From: Olly Mayhew [REDACTED]
Sent: 10 November 2020 11:06
To: Planning; Nicola Moore; Amber Willard
Subject: Fwd: Request for further information Y/122/20/NMA
Attachments: Y_122_20_NMA202011060959113585.pdf; OM010_NMA_10.11.2020.pdf; OM005 Proposed floor and roof plans.pdf; Arun Decision Notice 19.11.18.pdf

Please find attached a revised drawing (OM010_NMA_10.11.2020.pdf) as requested. The minor amendment to the front entrance is to move the entrance back 1m from the original plans.

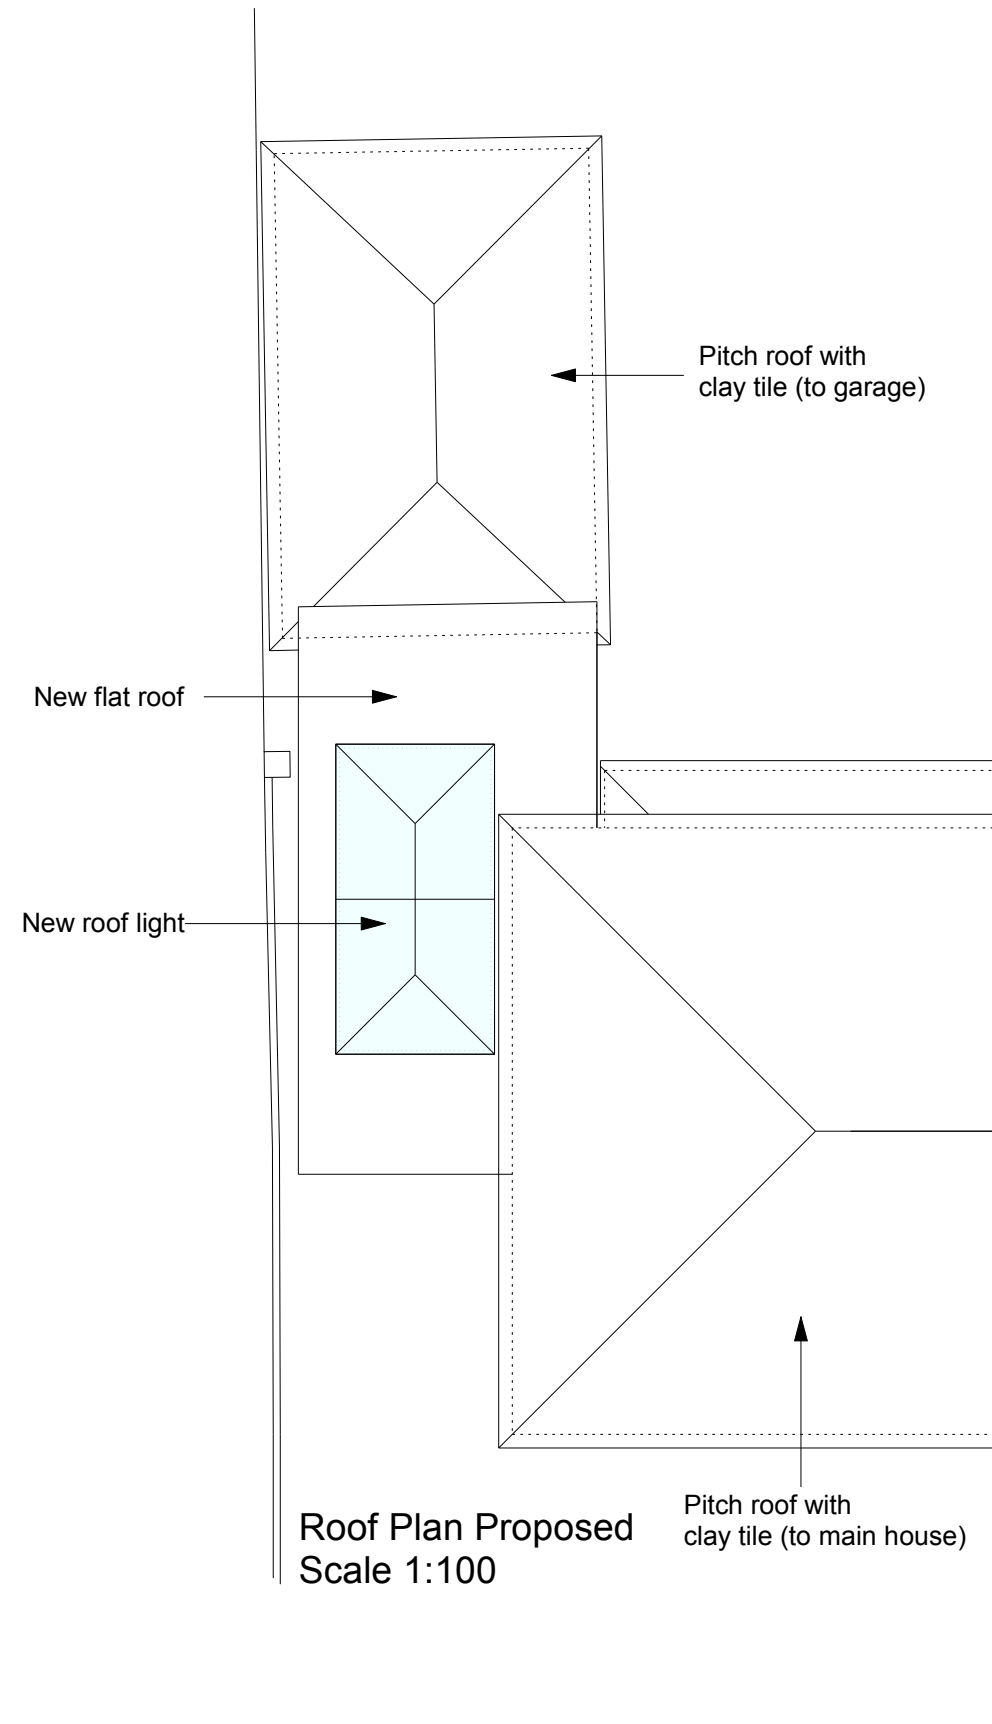
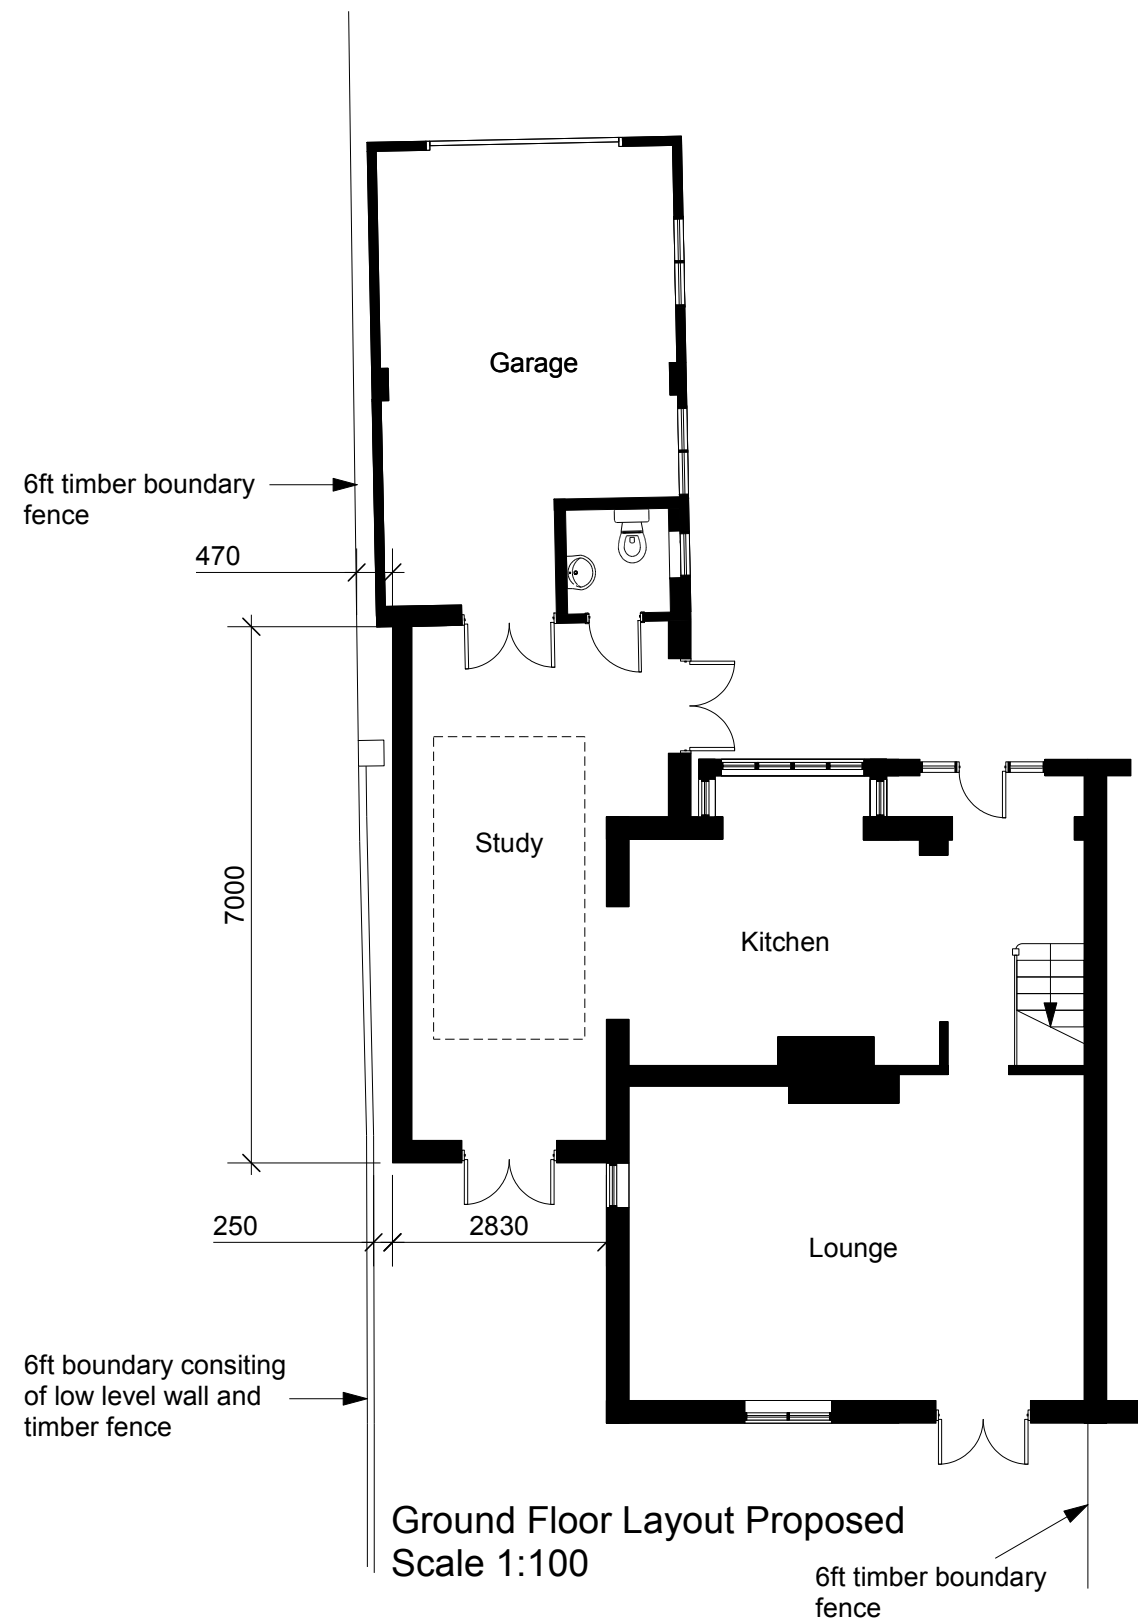
On another note, I have no record of drawing CM005 and so attach the original OM005 (OM005 Proposed floor and roof plans.pdf) which was the original proposed floor and roof plans for which the original planning application was approved. This drawing has not been altered in any way since the original application was approved and I assume the original approved drawings will still be logged against the original application in your planning portal with reference ([REDACTED])

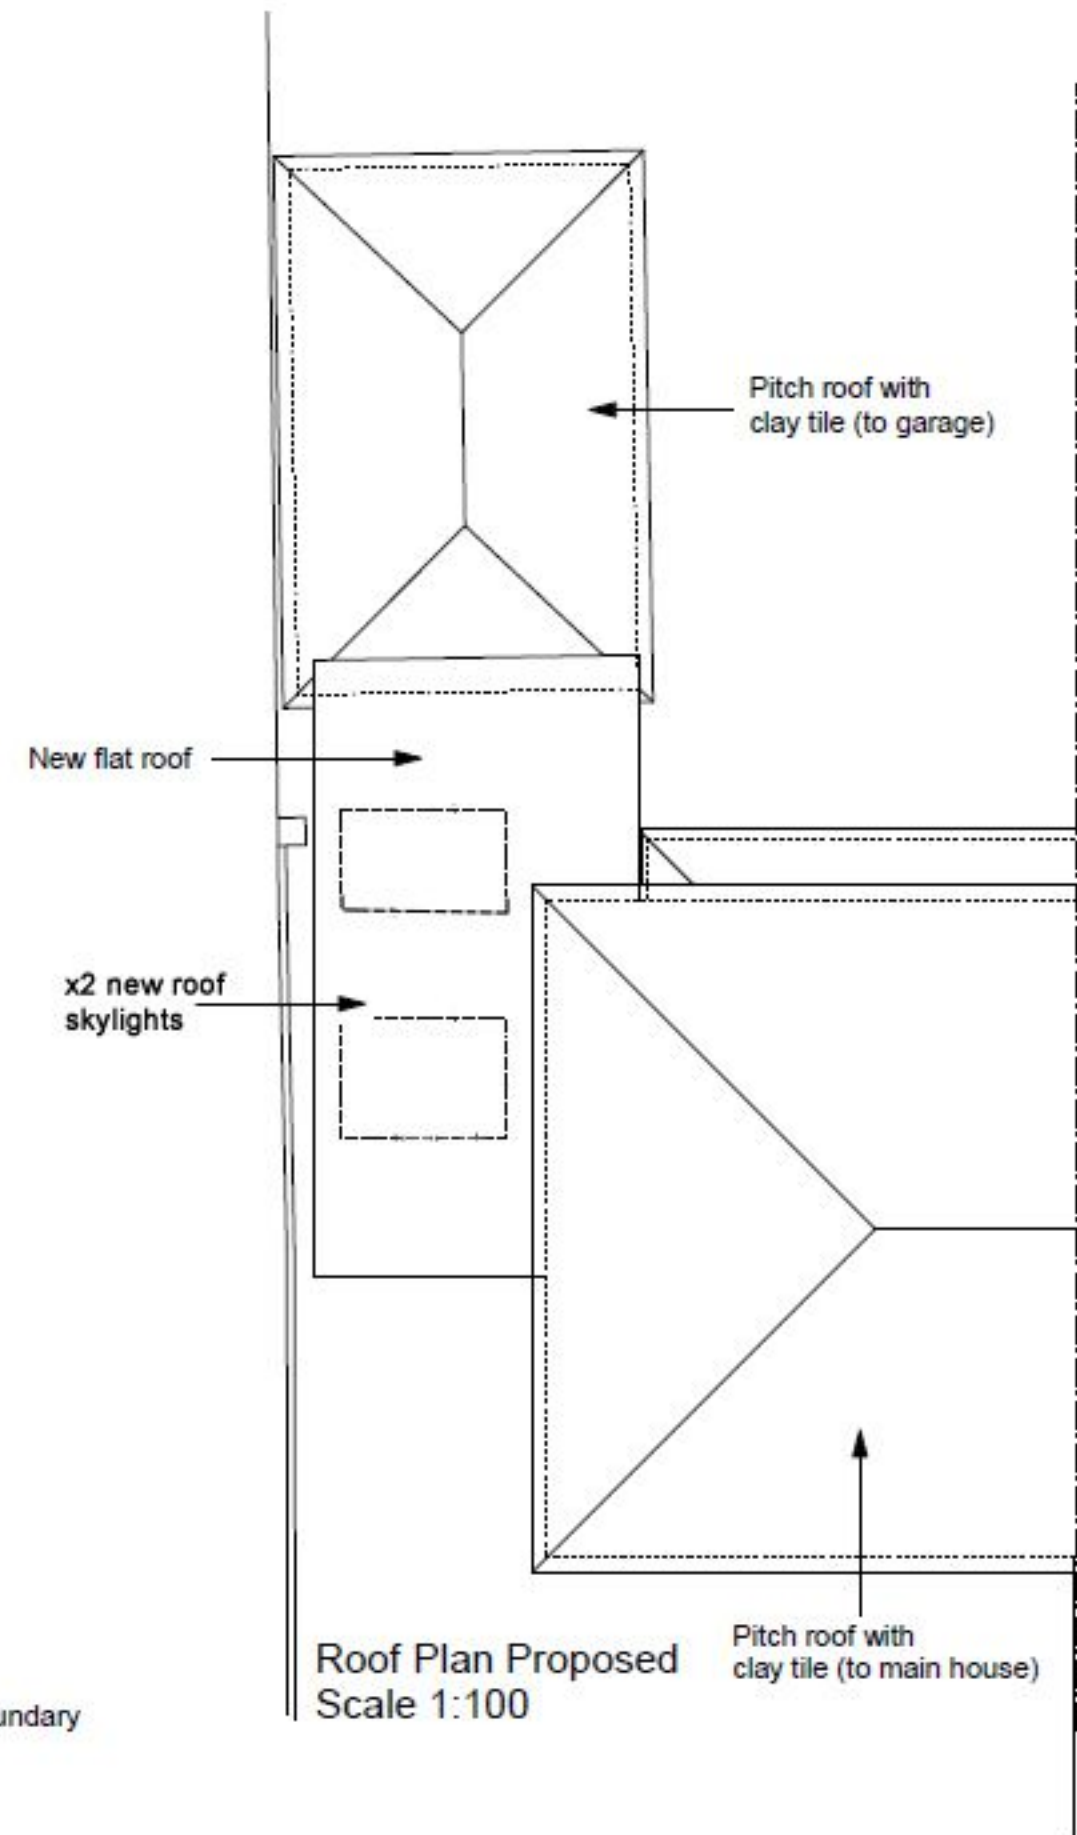
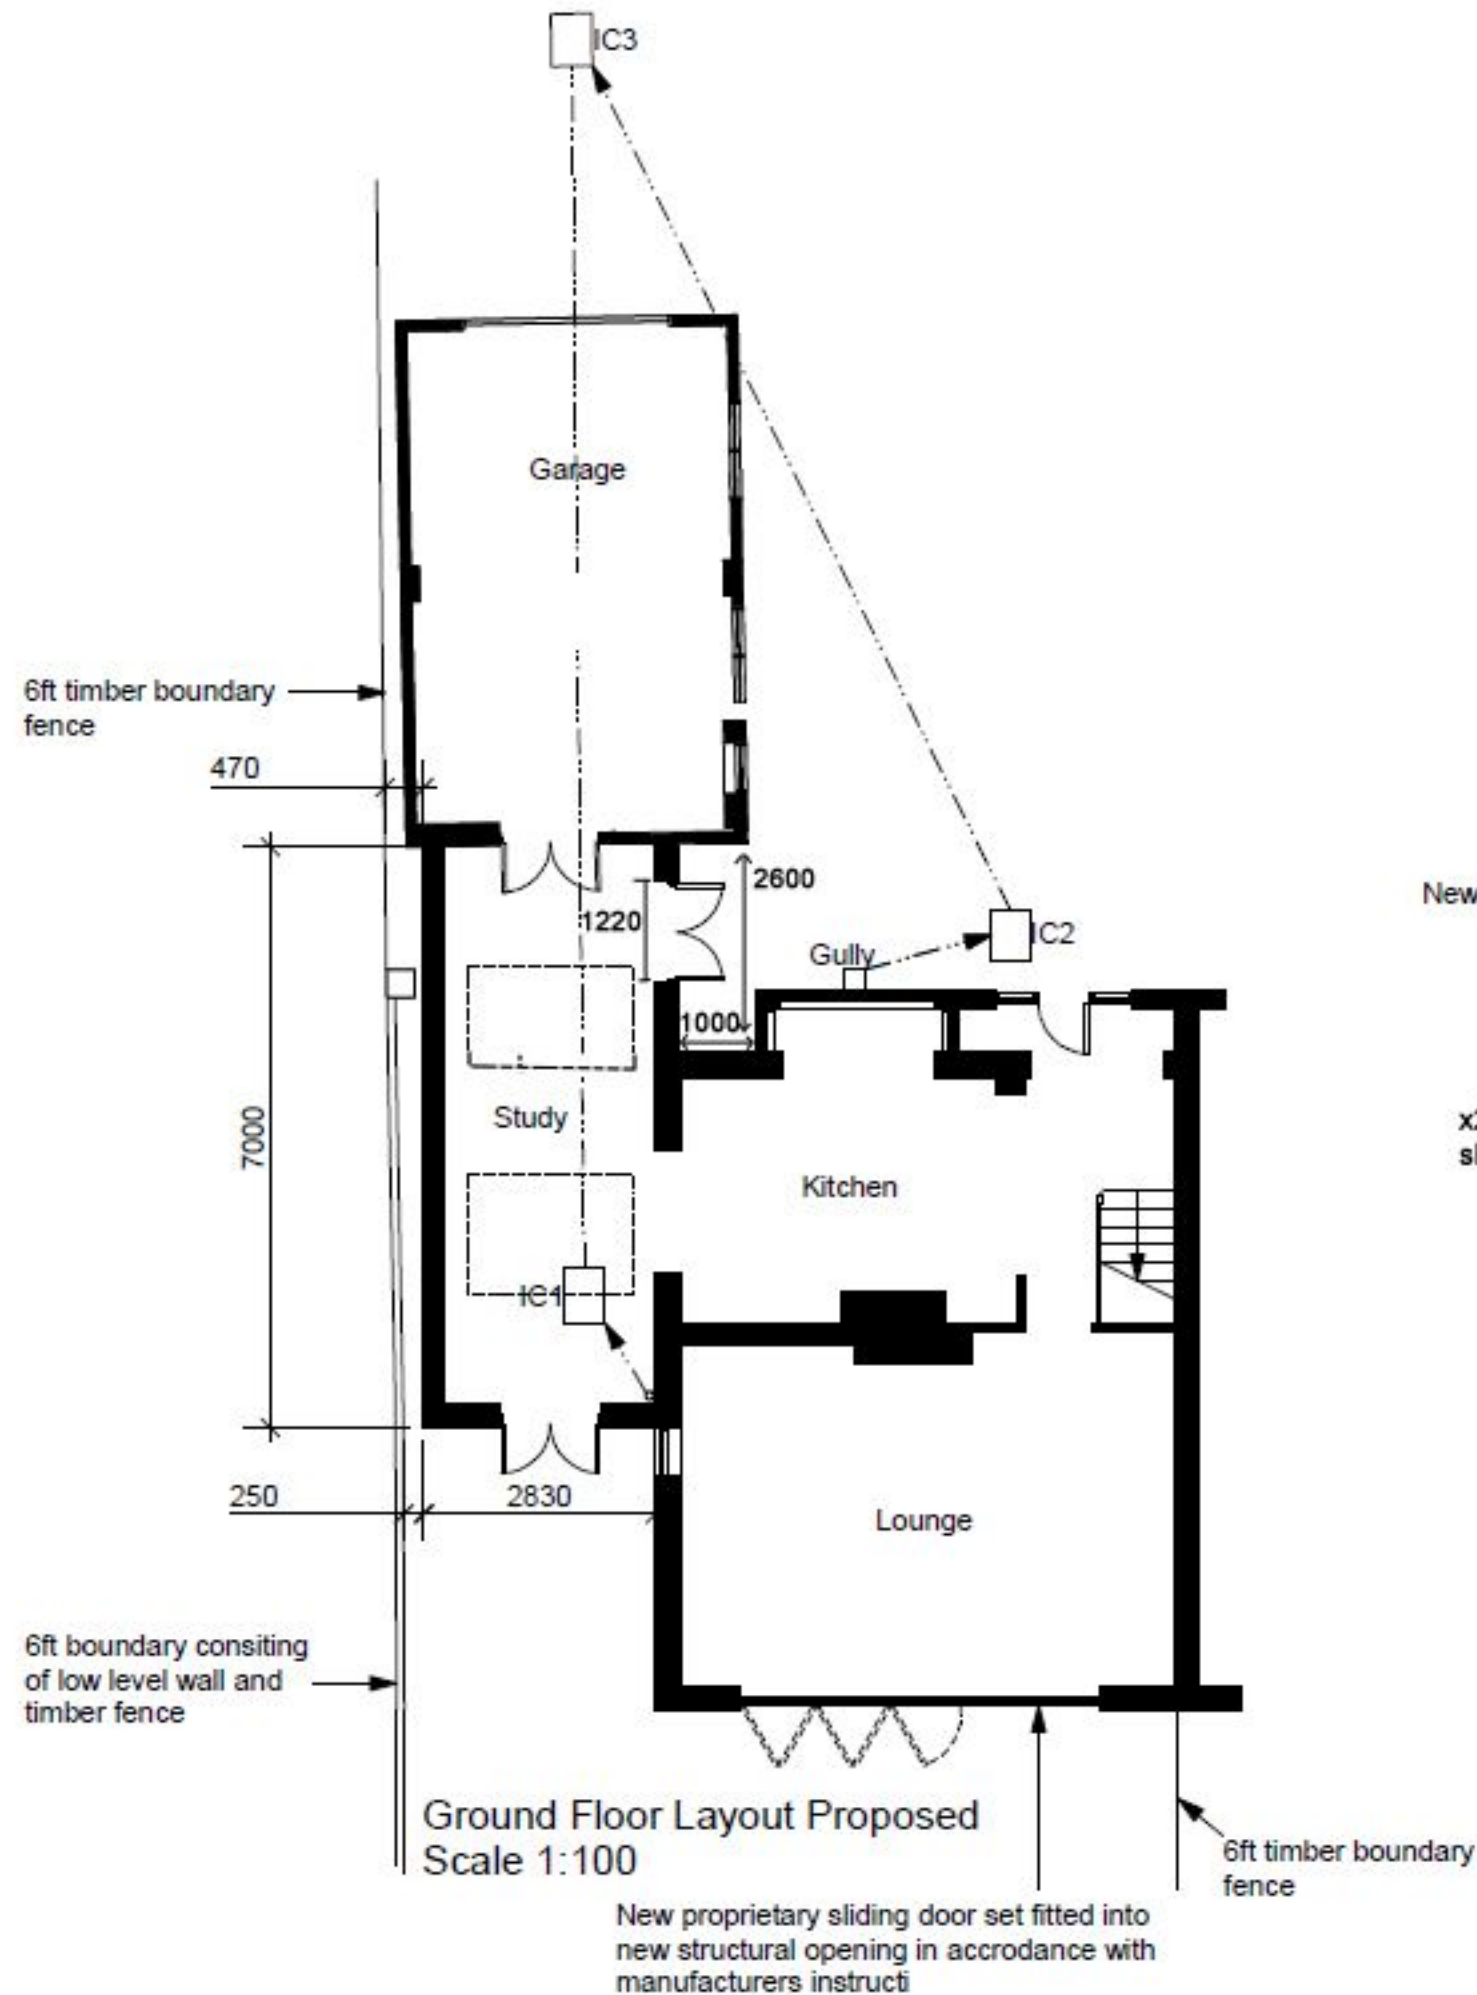
This is to give a covered entrance porch.

I have removed the scale from the drawing and added dimensions for the revision and patio doors as requested. There is no amendment to the width of this proposed wall or the patio doors compared to the original, approved application (Y/77/18/BR).

We just wish to move this back by 1m to give a covered entrance. The flat roof dimensions will be as per the original, approved plans.

Again, this is a very minor adjustment to the approved plans to give a covered entrance and to change the single large roof lantern to two smaller skylights.
